From: Biazar, Shahab
Sent: Friday, November 15, 2013 9:41 AM
To: 'rob.adams@adams-engineering.com'; 'Leslie Ford'
Cc: Sims, Timothy E.
Subject: RE: McDonald's 12th and Indian School, Grading and Drainage Plan (H13/D009) and (H13/E009)

The following are the comments regarding the Grading and Drainage Plan and Erosion Sediment Control (ESC) Plan for McDonald's 12th and Indian School.

Grading and Drainage Plan comments (H13/D009):

POST DEVELOPED DRAINAGE PLAN  
SEC OF 12TH ST. & INDIAN SCHOOL RD., ALBUQUERQUE, NM

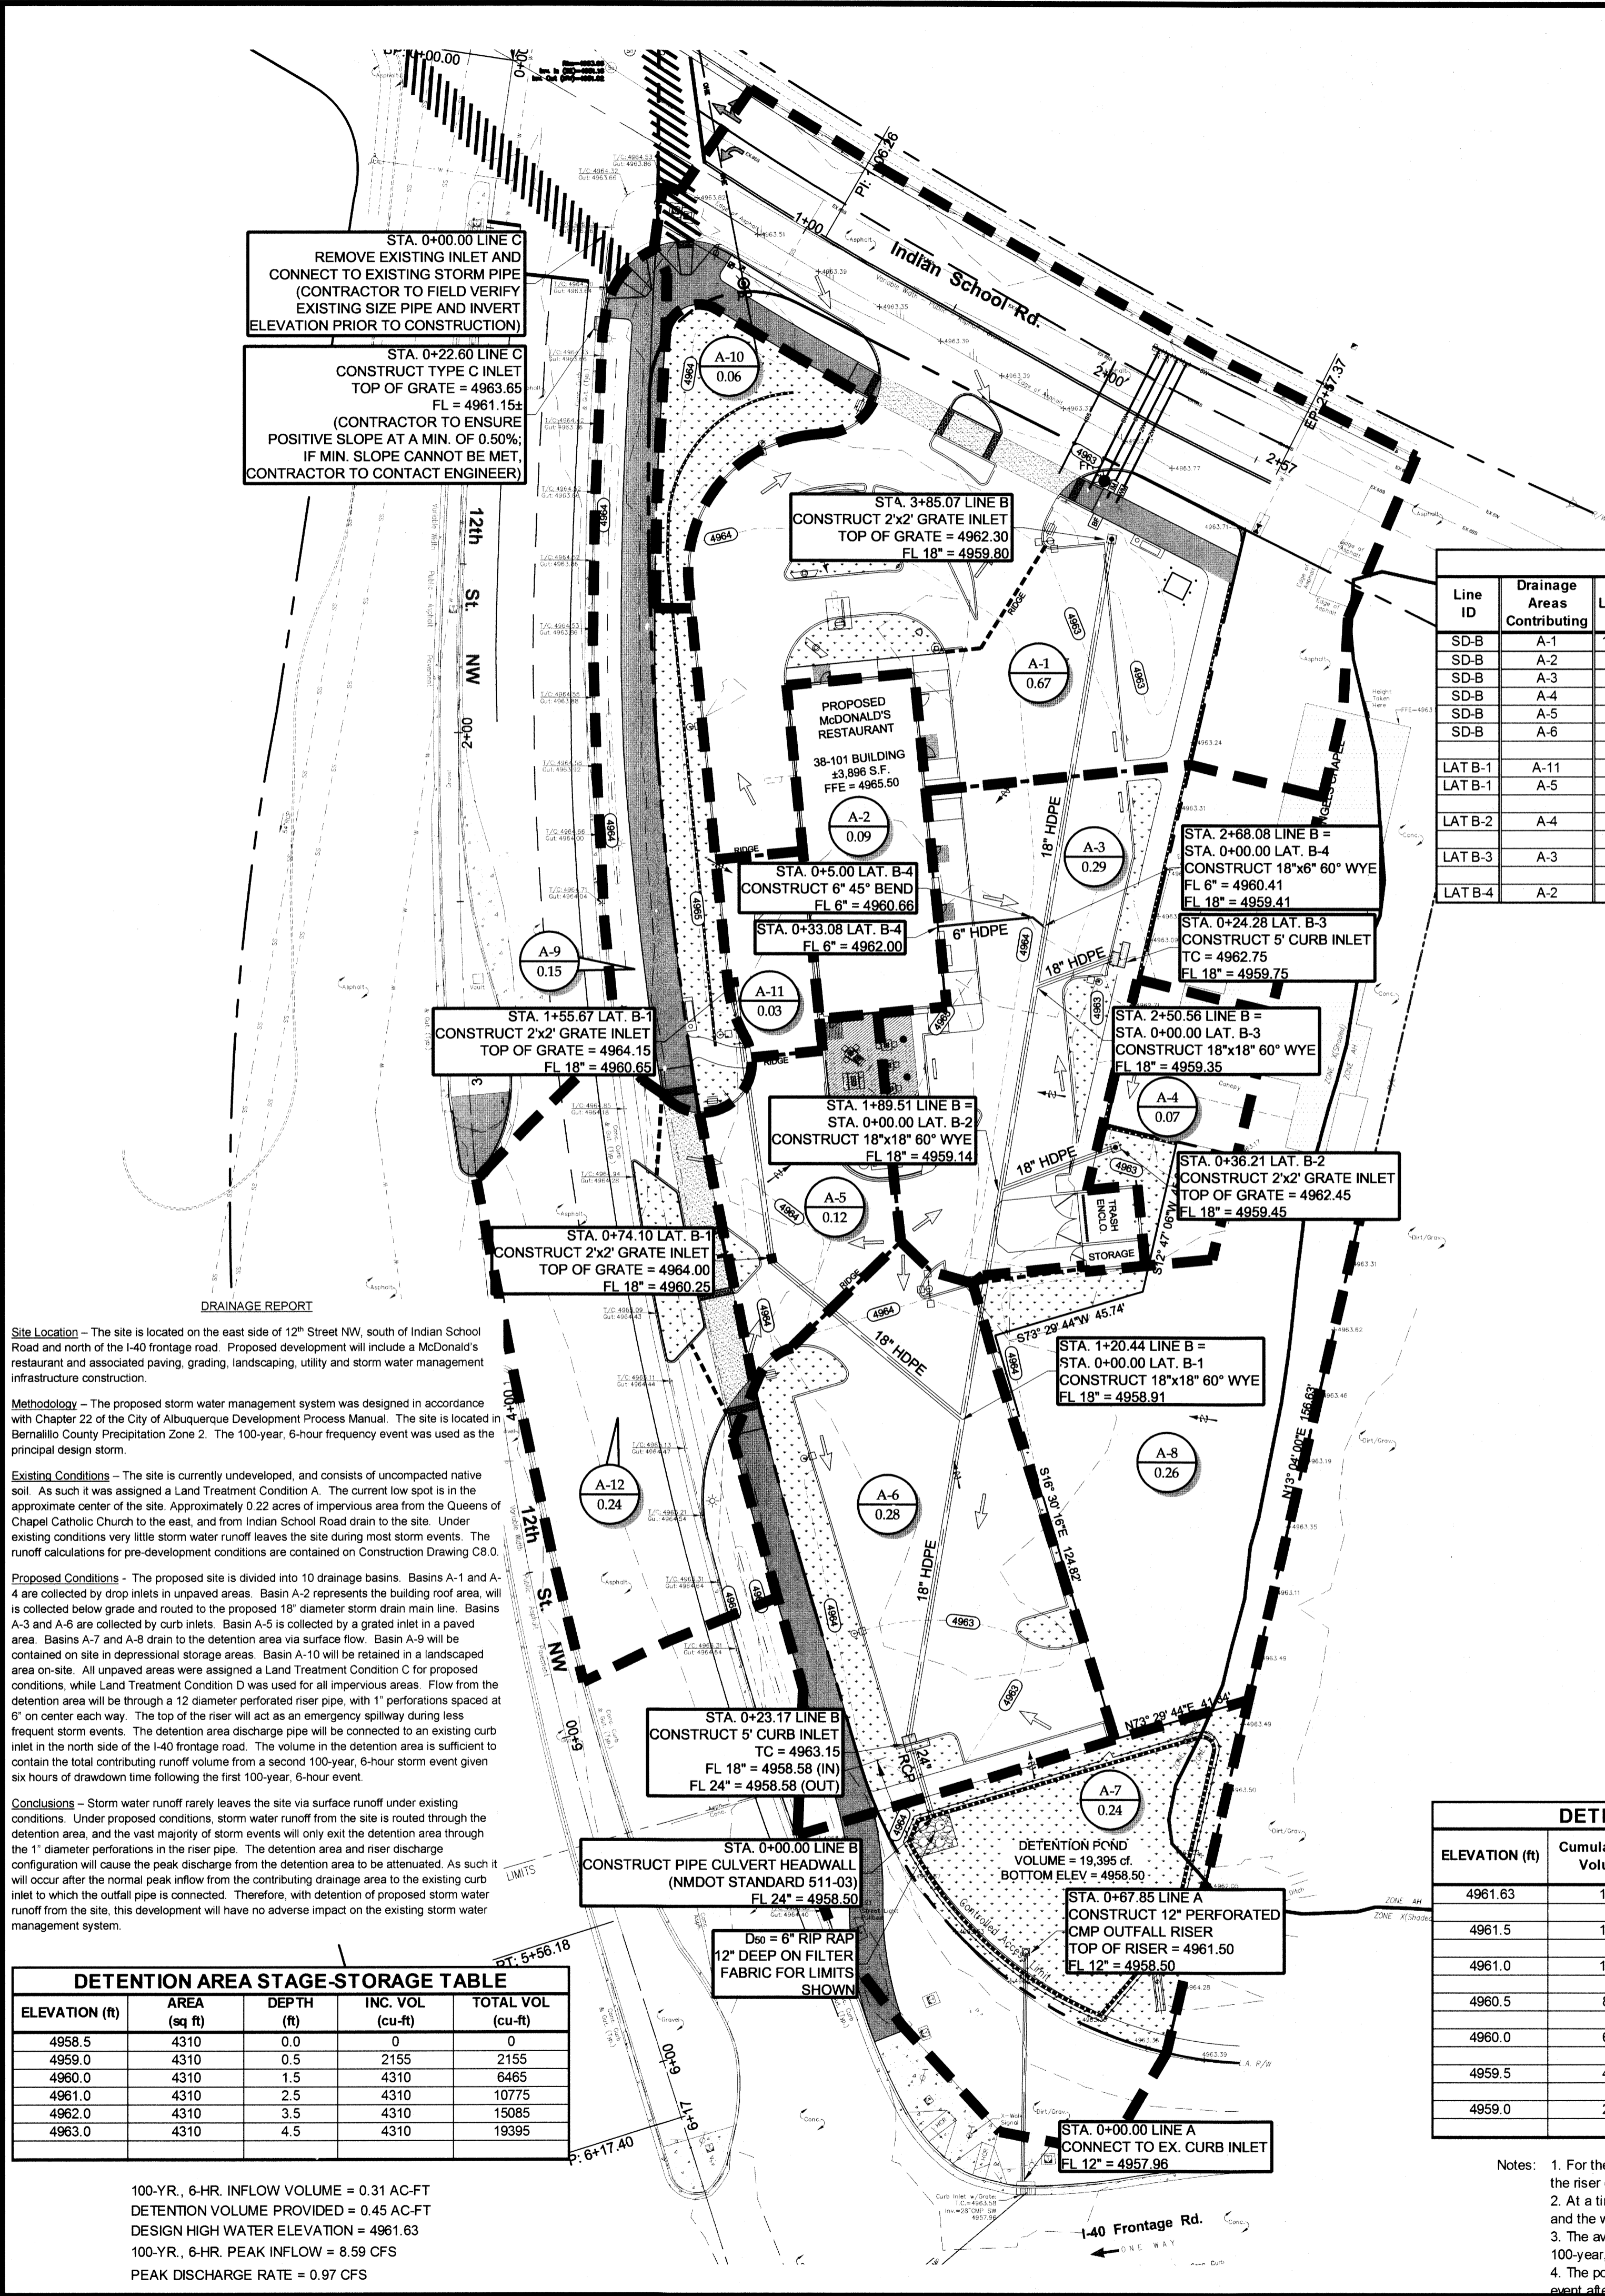
1. Please provide a detail for the Riser in the pond.
2. How much runoff is being intercepted by the inlet within the State Highway right-of-way where McDonald's pond is being discharge to. Will the runoff depth in the inlet cause an overflow. Invert from the 12" pipe connection must be higher than the invert of the 27" CMP in the inlet.
3. A Floodplain Development Permit is required for Building Permit approval, due to the AH Zone. A copy of this permit is attached.
